**RE: Caliber Collision – 250 98th ST NW  
Erosion and Sediment Control Plan (Sheets 9, 15, 24, & 25 of 25)  
Engineer's Stamp Date 7/31/24 (K09E048D)**

Based on the information in your 2<sup>nd</sup> submittal received on 8/2/24, the ESC plan cannot be approved until the following comments have been addressed.

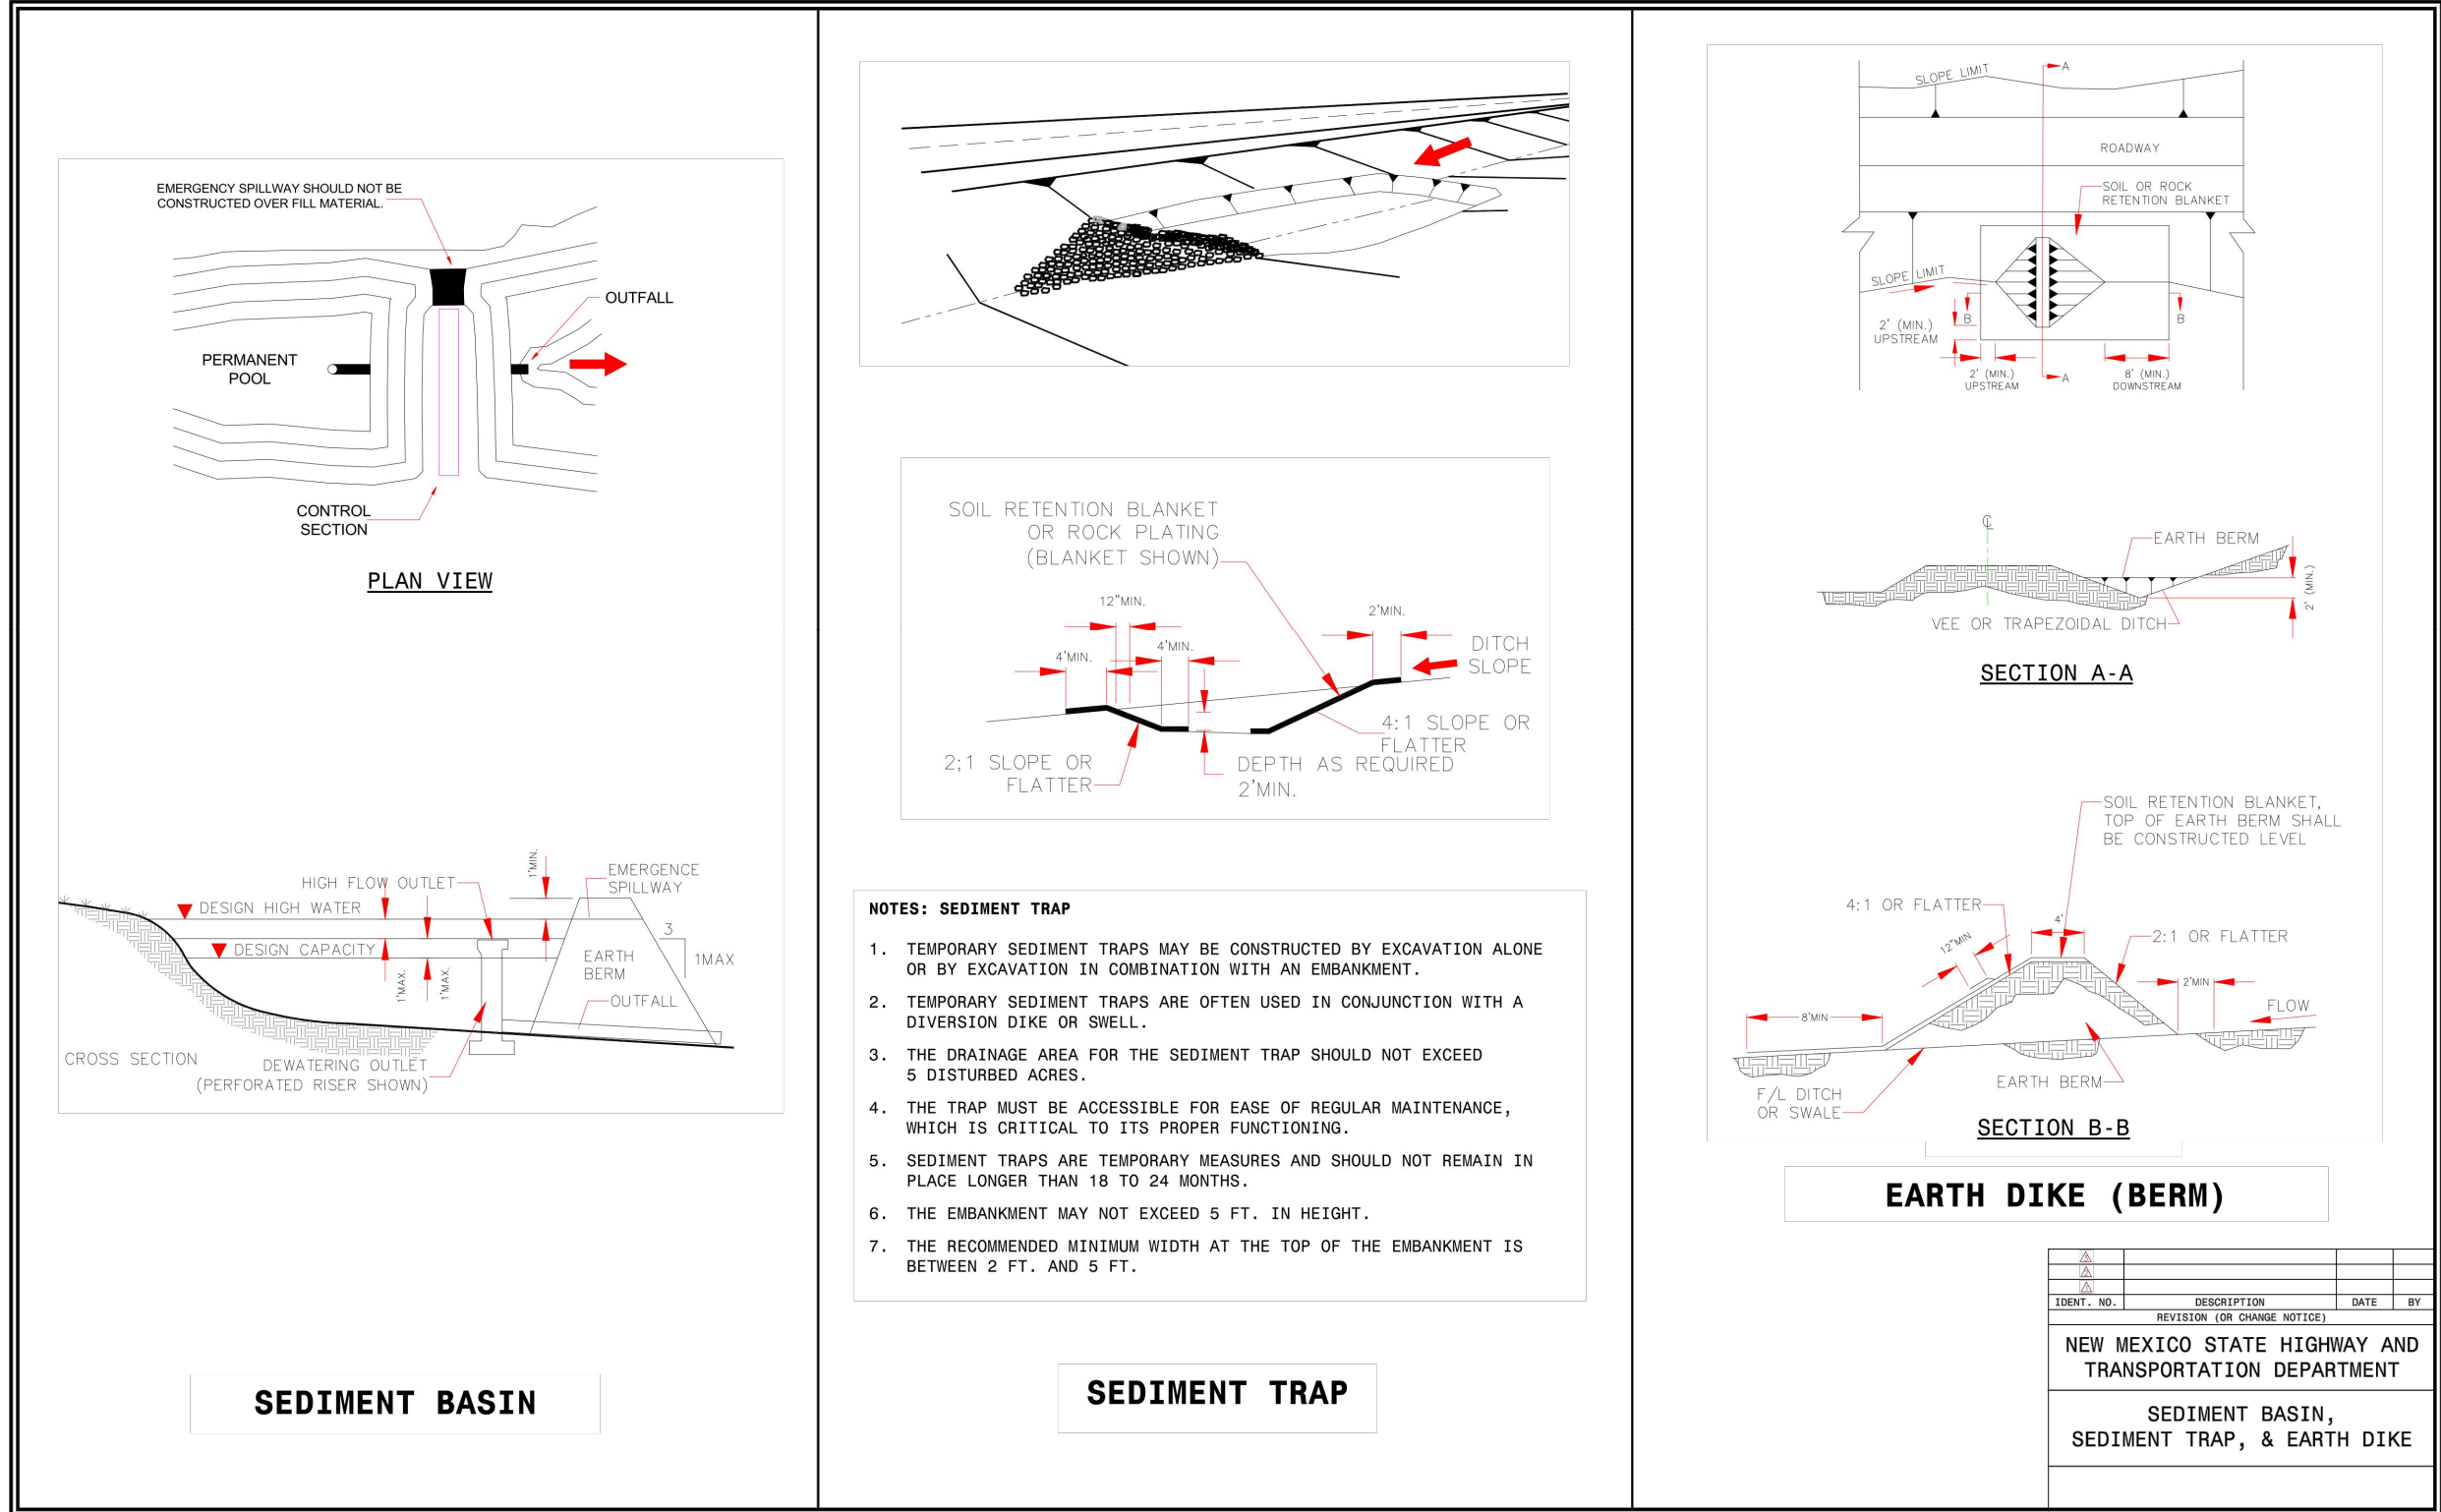
4. The existing temporary sediment trap located on this site, Tract F2, serves both Tract F1 and F2. Provide design calculations and construction specifications on this plan to ensure uninterrupted sediment basin protection for both tracts in accordance with CGP 2.2.12.c & 2.2.12.d until the entire area satisfies the Final Stabilization Criteria of CGP 2.2.14.c.

6. The previous property owner didn't provide ground cover that satisfies the Final Stabilization Criteria at CGP 2.2.14.c for this 2.5-acre site; therefore, it is the new property owner's responsibility. The SWPPP must include site-specific interim and permanent stabilization per CGP 9.6.1.c.i. The Landscape Plan can be used to satisfy this requirement and should be submitted separate from the ESC Plan with the application to the Stormwater Quality Section of the Planning Department and they should be included in the SWPPP. Provide a specification on the ESC Plan for any disturbed areas not covered by the Landscape Plan.

7. Include the location of earth-disturbing activities, past, present, and future for the entire 2.5-acre site, except the portion already paved, in the limits of disturbance, and include the location of any off-site construction support activities per CGP 7.2.4B.

8. Add a site-specific schedule, sequence per CGP 7.2.6.iv, of stormwater control installation/implementation, including the existing temporary sediment trap that serves both Tract F1 and F2. Include the removal of temporary controls as necessary to comply with the "Conditions for Terminating CGP Coverage" CGP 8.2.
